# Construction Drawings (PlansProfiles)\_v1.pdf Markup Summary

## 8-29-2022

Cursory comments

OVERALL SHEET

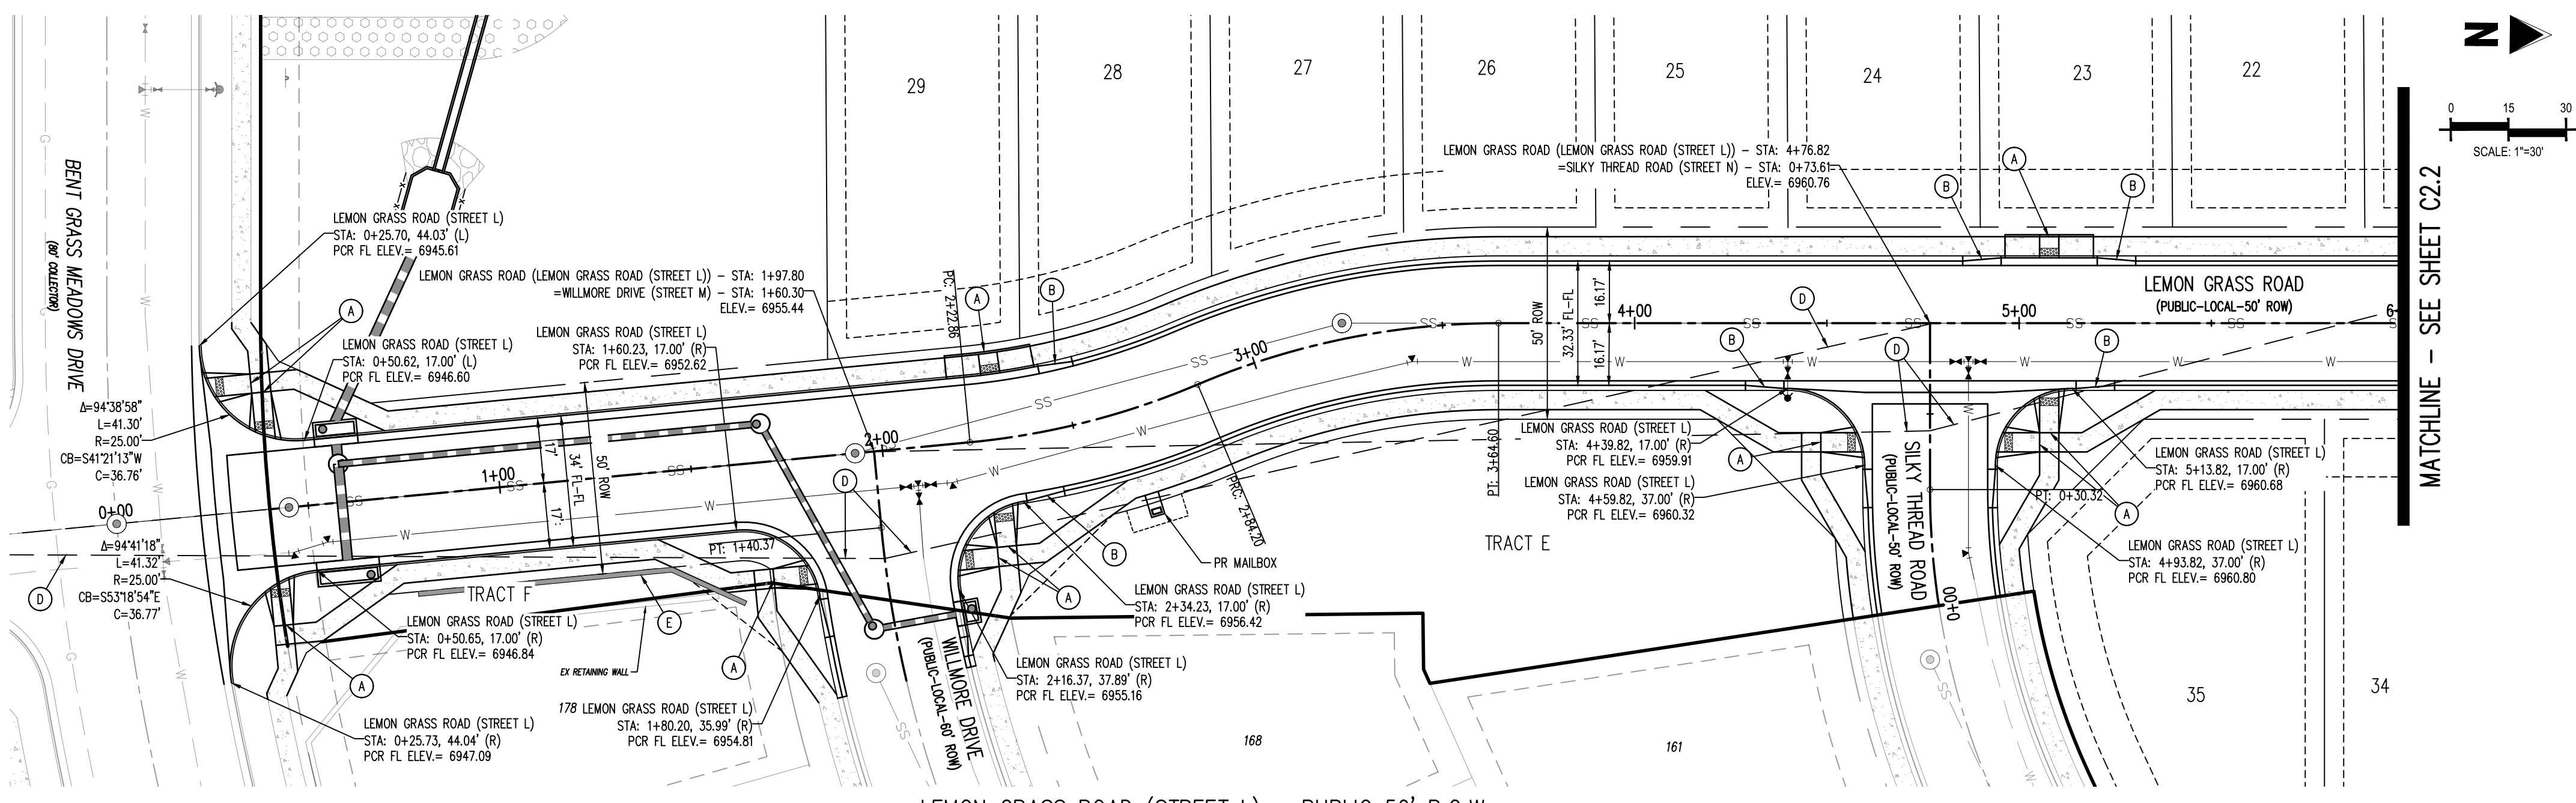
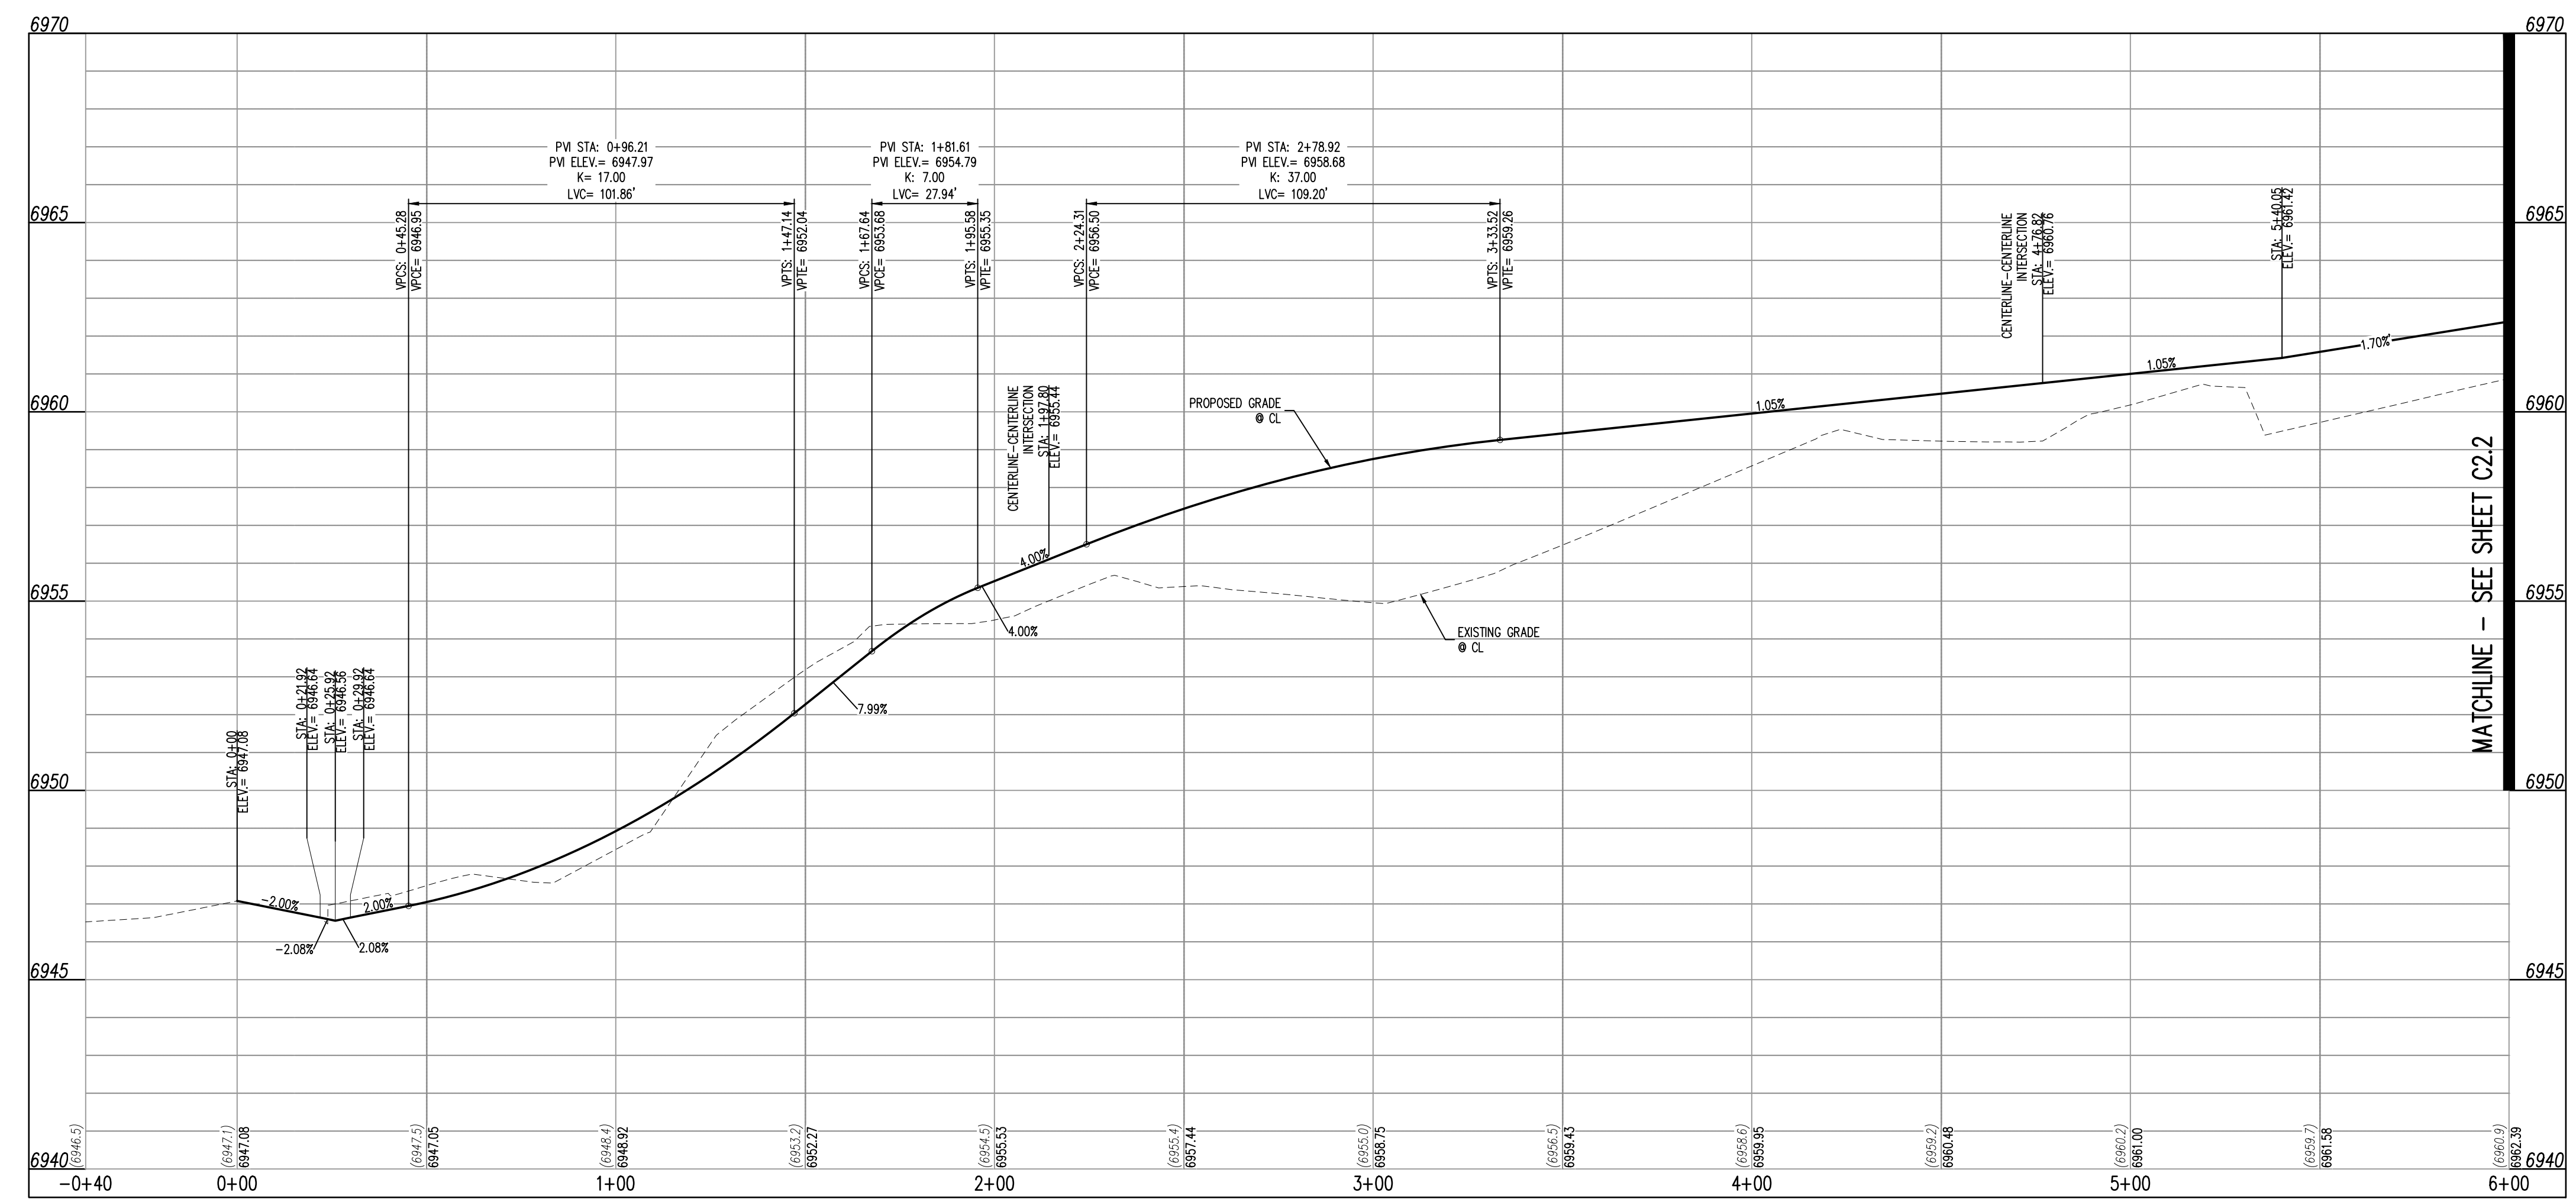
Adjust/add tracts per other comments
